**A303 Amesbury to Berwick Down  
(Stonehenge) Wiltshire  
TR010025**

**Wiltshire Council (A303-AFP022)  
Review of 3.1 Draft Development  
Consent Order (Rev 1) (000770)  
Submitted at Deadline 2**

Application Document Number	Rev
TR010025 - 2.12	P03

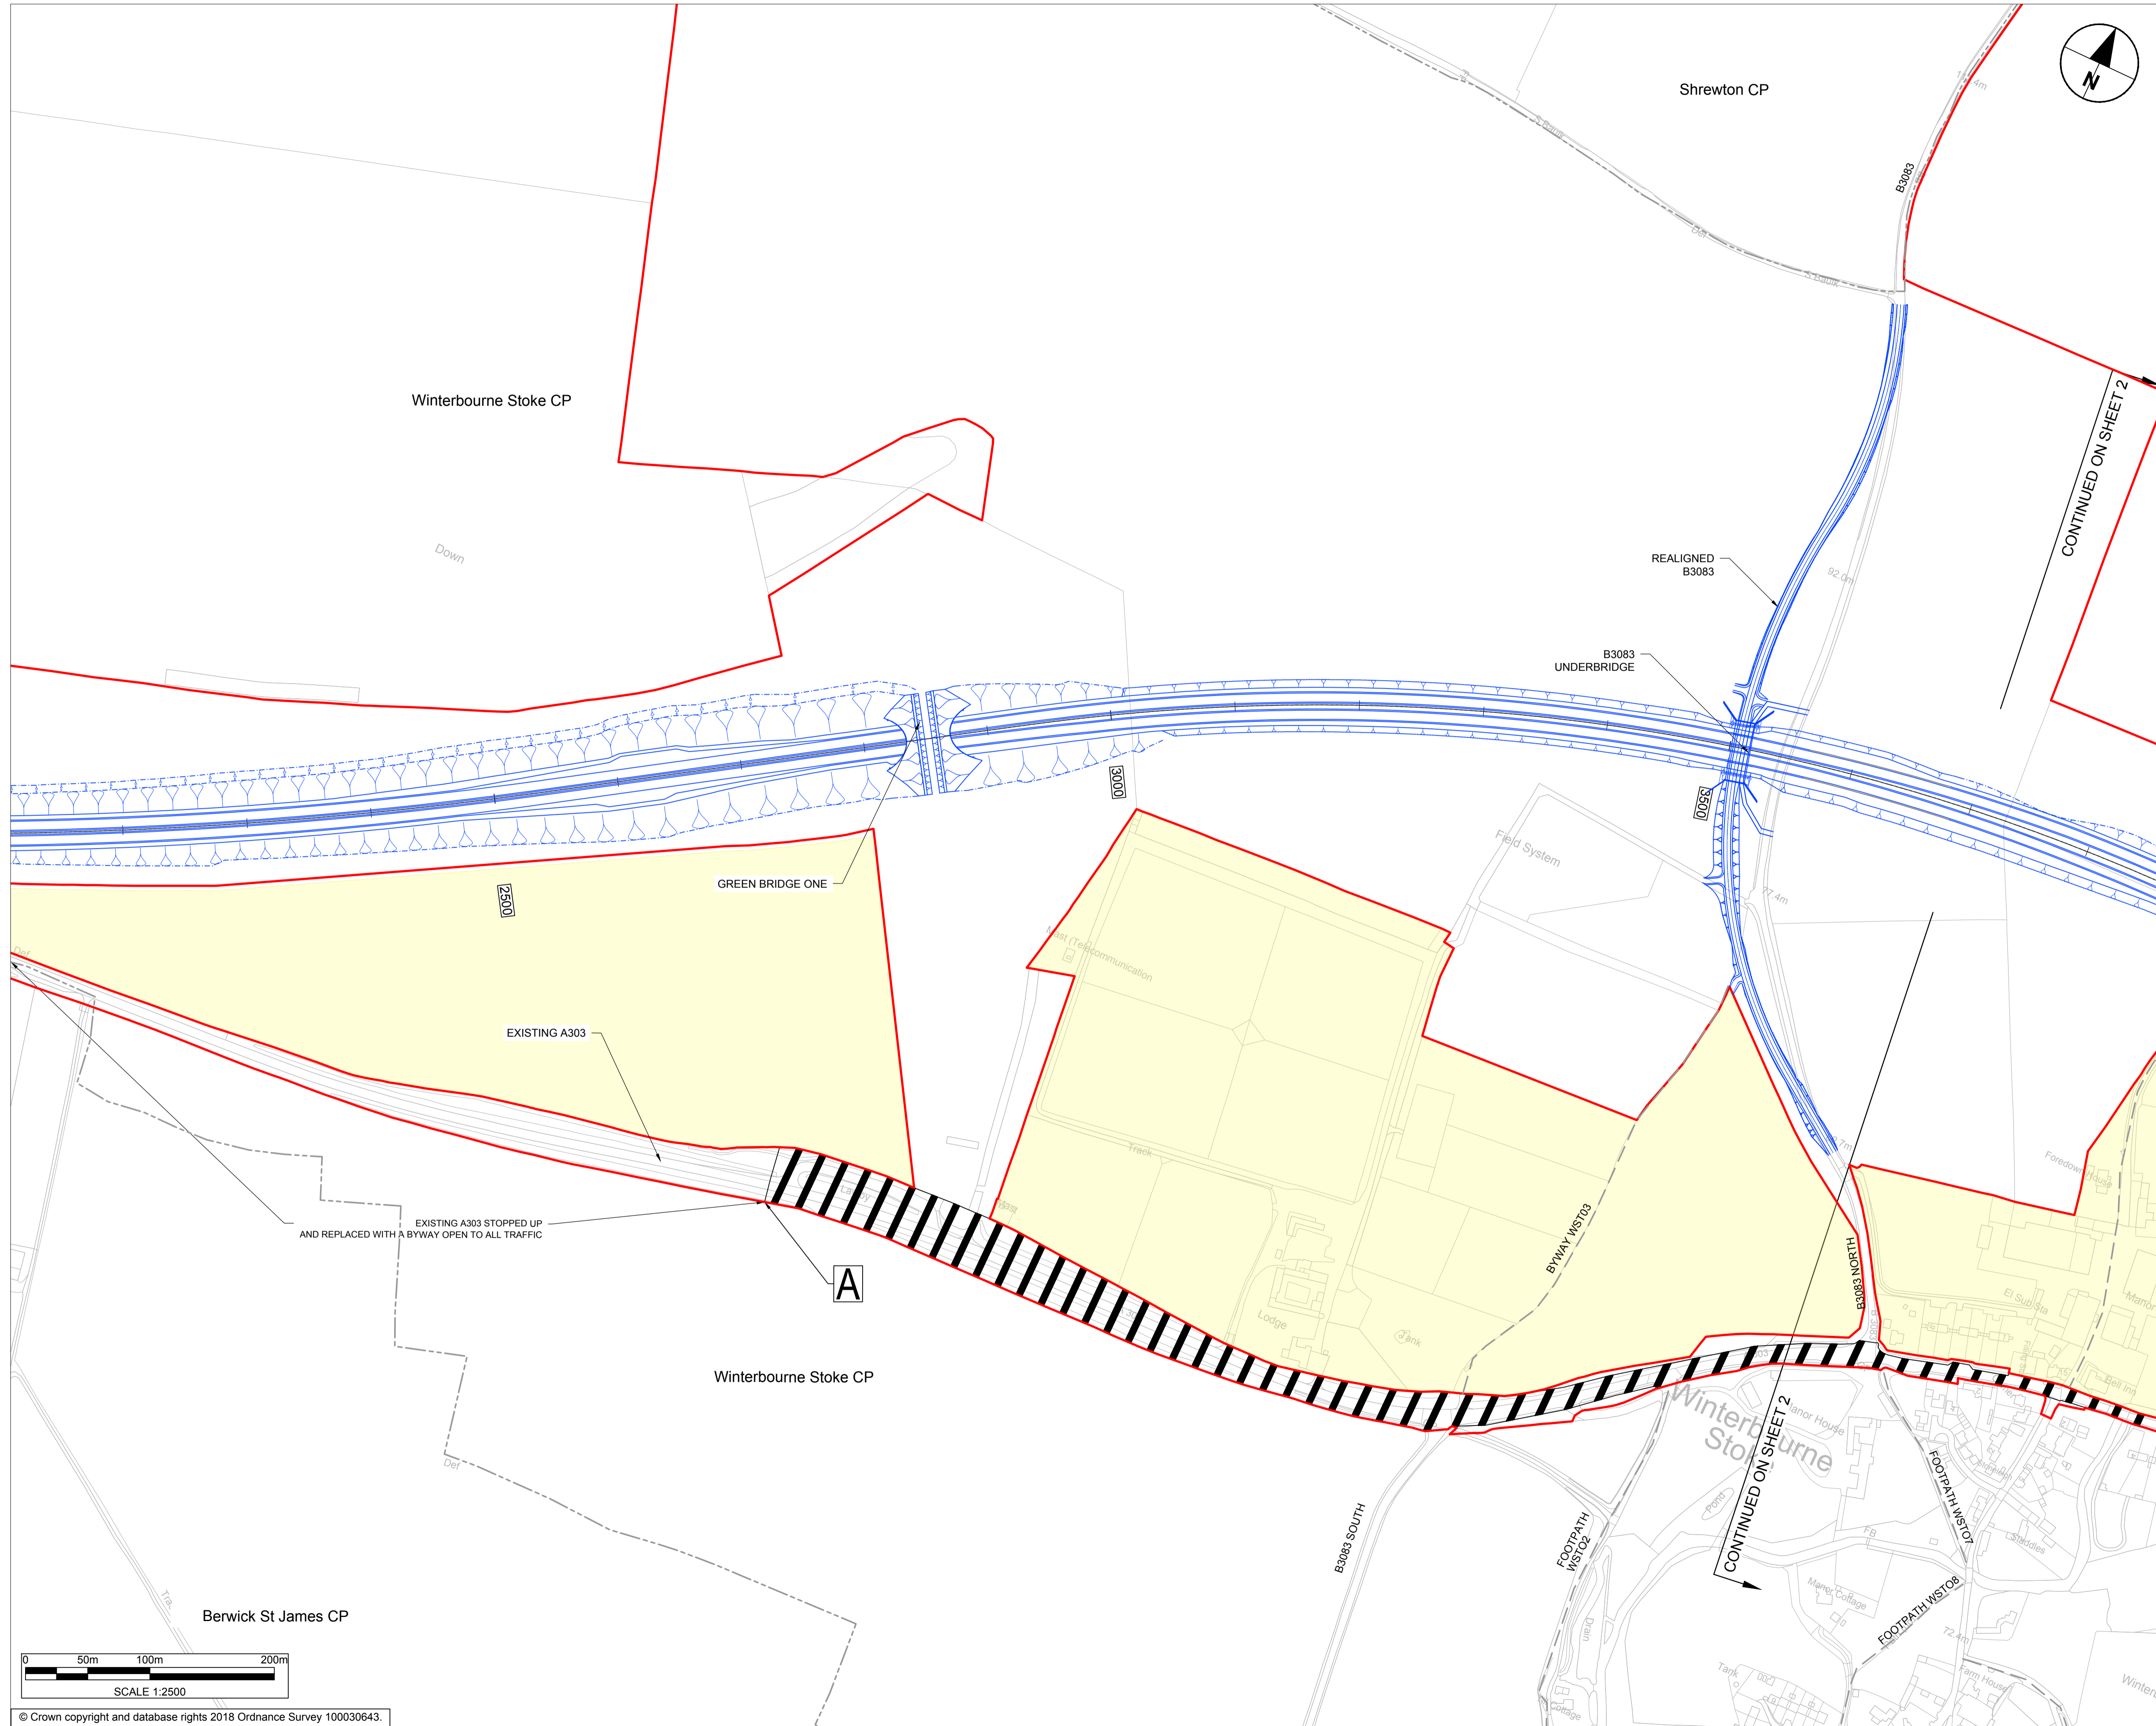
As outlined within the Council’s written representation submitted at Deadline 2, the Council considers that changes to this section are required. If incorporated, amendments would also be required to be made to the de-trunking plans. The Council suggests that sub-clause (22) is amended to state “...on sheet 1 of the de-trunking plans, *including the layby to the west of Scotland Lodge Farm, ...*”.

Application Document Number	Rev
TR010025 - 2.12	P03

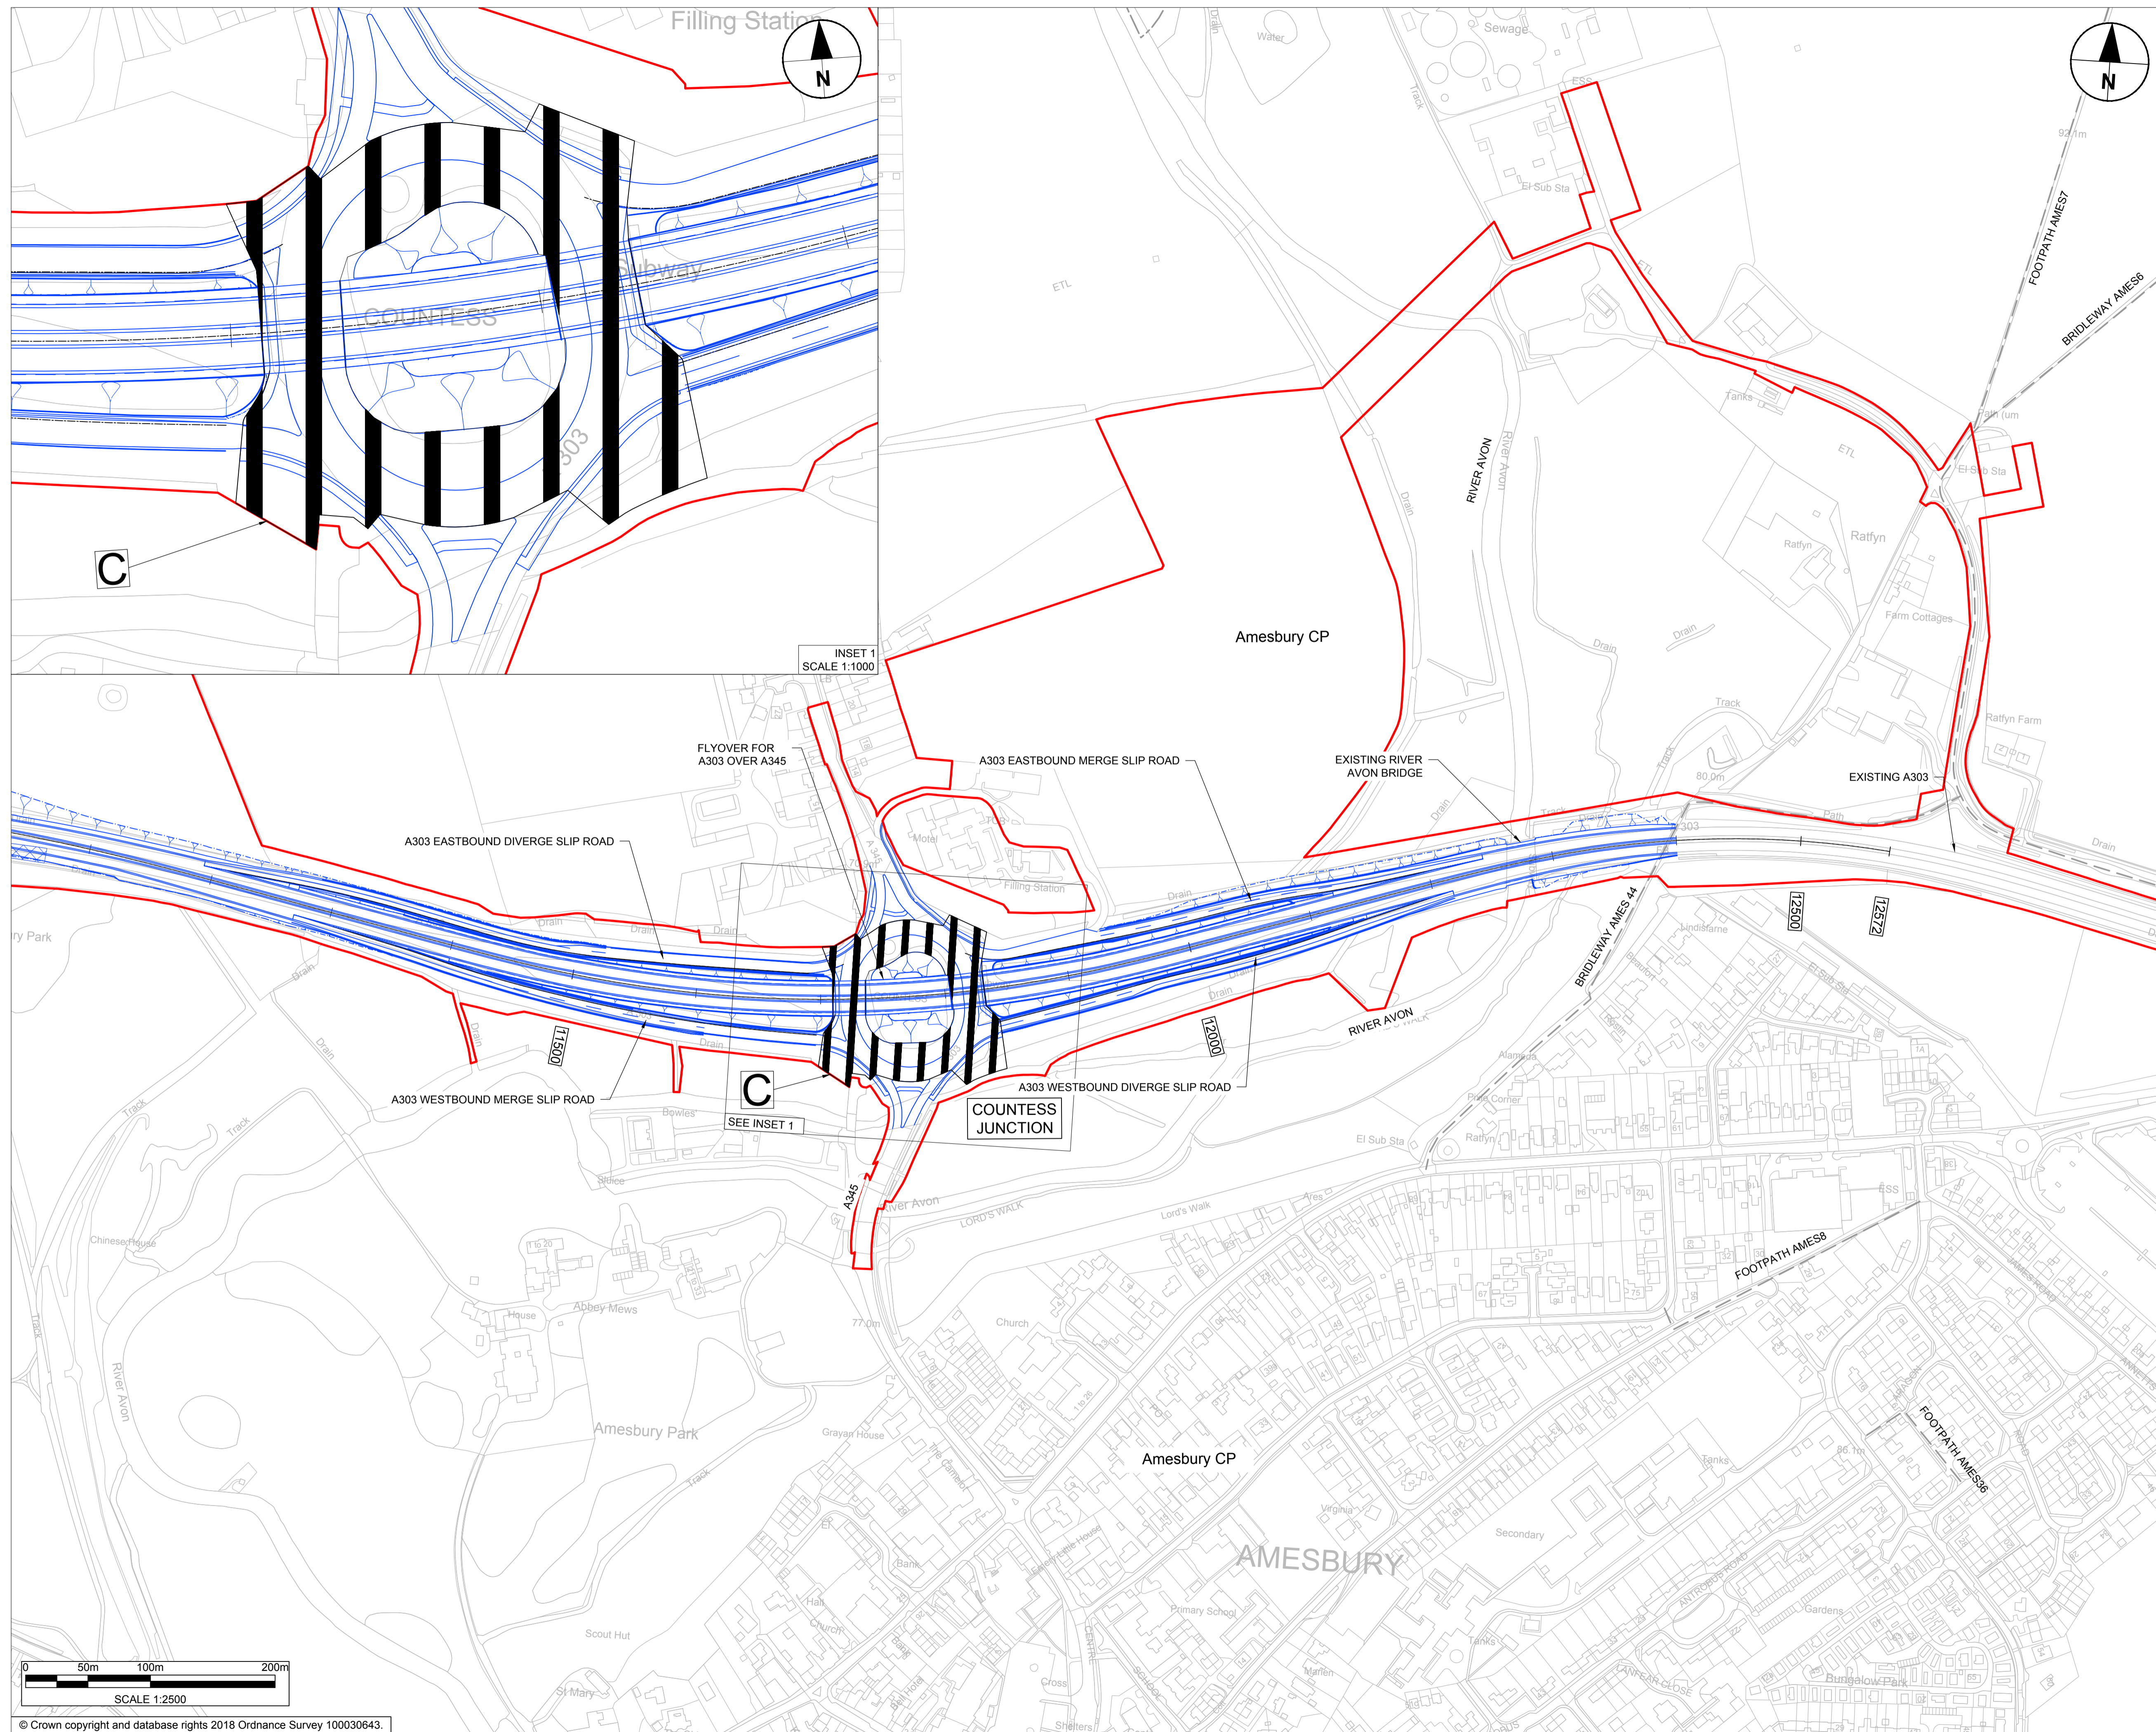
Furthermore, the Council suggests that an additional sub-clause (23) is added as follows “*The circulatory carriageway, verges and central part of the Countess Roundabout, as shown on sheet 3 of the de-trunking plans.*”
